CITY OF ALBUQUERQUE

May 5, 2017

Re: 3440 2nd St NW
Request 30-Day Temporary C.O. - Accepted
Engineer's Stamp dated: 11-24-14 (G14D087)
Certification dated: 4-24-17

3440 2ND STREET, NW GRADING AND DRAINAGE PLAN			
DRAWING:	DRAWN BY:	DATE:	SHEET #
201424-GR.DWG	SH-B	10-22-2014	1

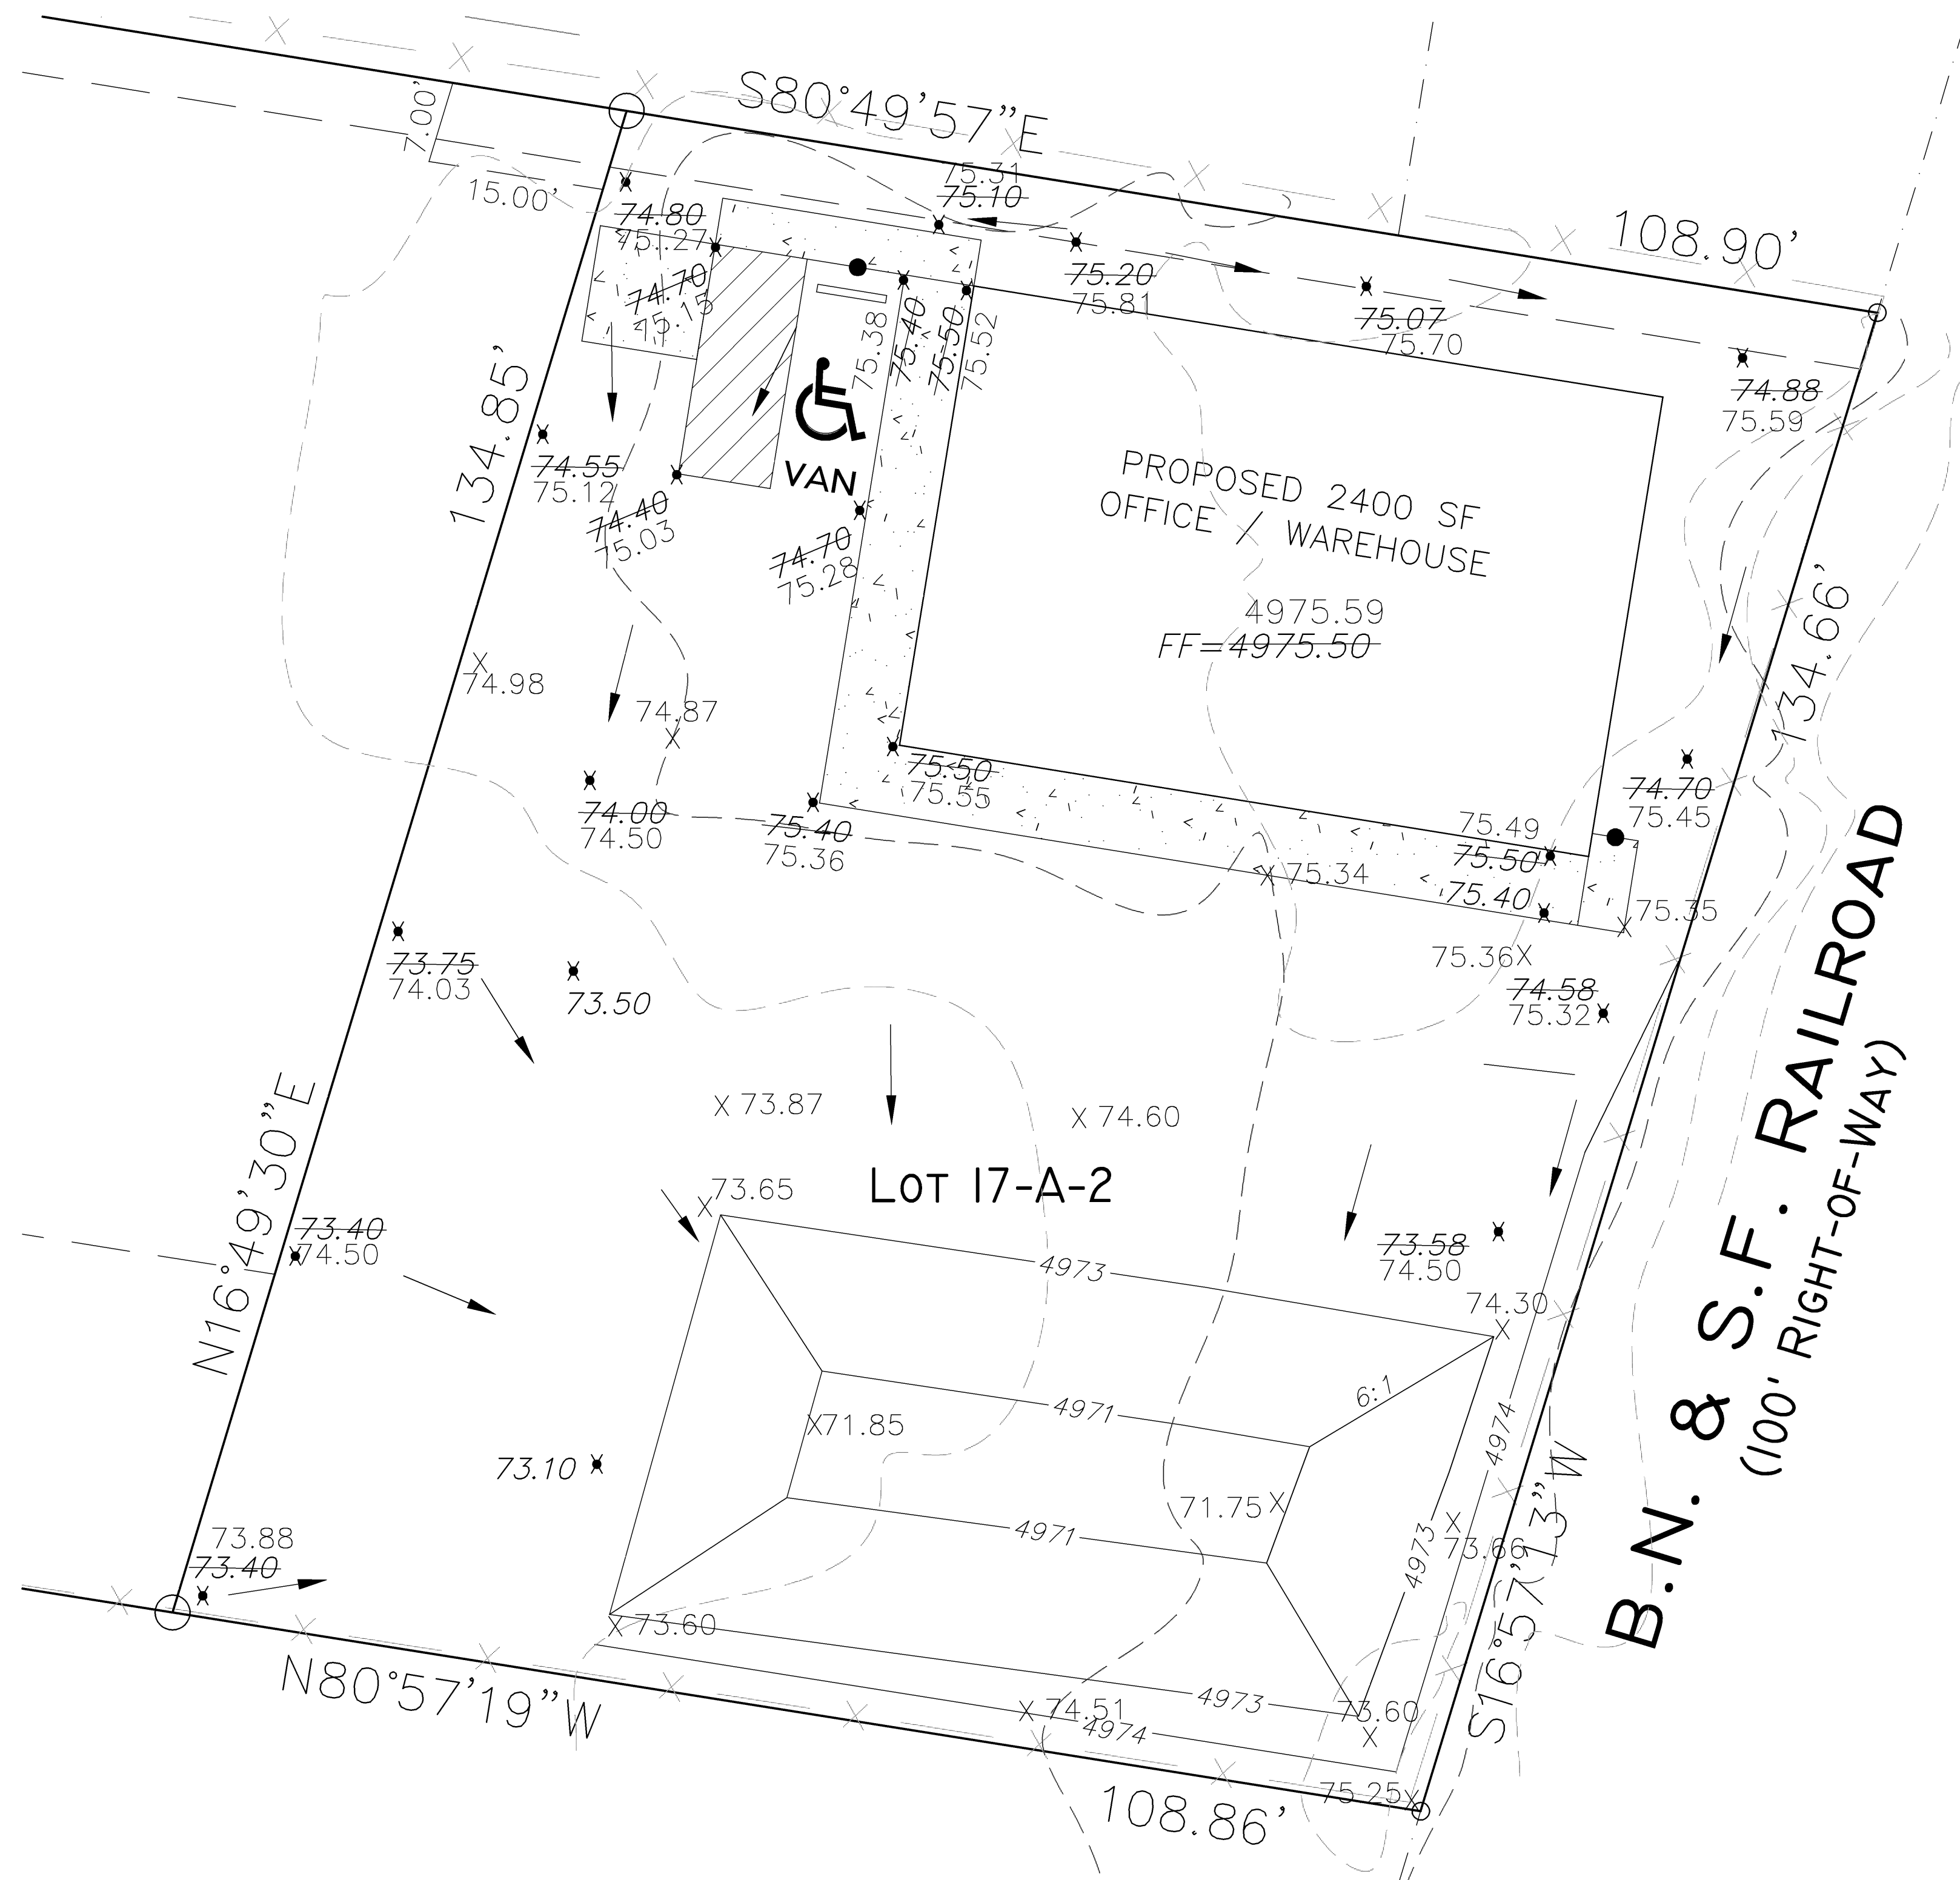
Based on the Certification received 4/28/2017, the site is released for a 30-day Temporary Release of Occupancy by Hydrology. However, before a permanent CO can be accepted the following comments must be addressed.

- A swale must be in place from the SW downspout to the pond.
- A swale must be in place from the mid-point along the west side of the lot (spot elevation 74.98) to the pond.
